Town & Country Planning Act 1990 (as amended)
Town & Country Planning (Development Management Procedure) (England) Order 2015
Application for Planning Permission for Works or Extension to a Dwelling

Development Replace conservatory with extension and enlarge front entrance hall

Location 8 Longships Littlehampton

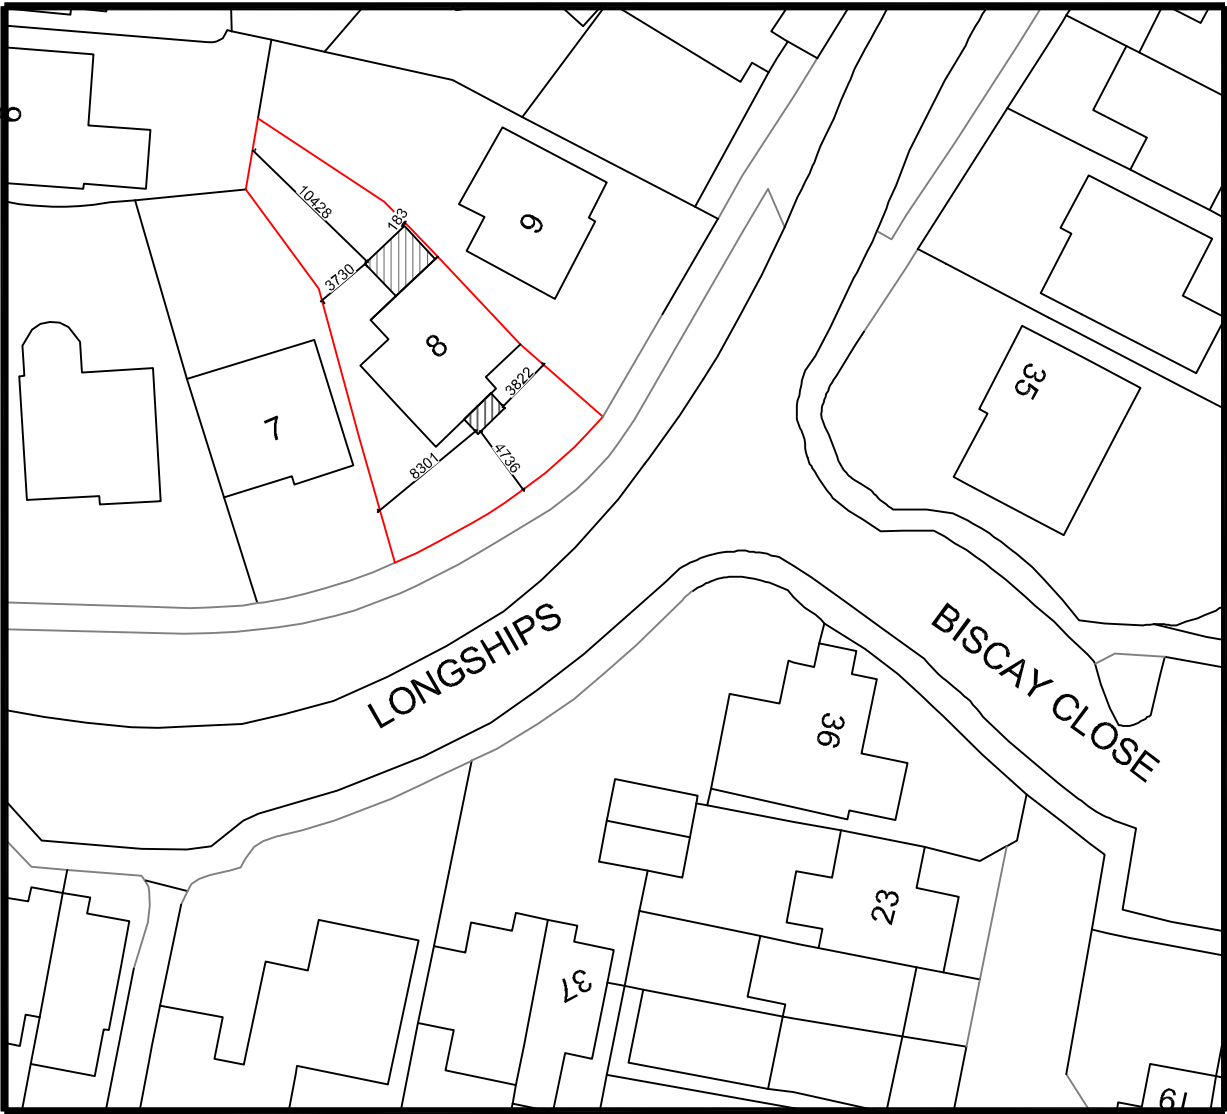
Block Plan: Please include dimensions from the extension to all site boundaries. Please also include the proposed porch on the block plan.
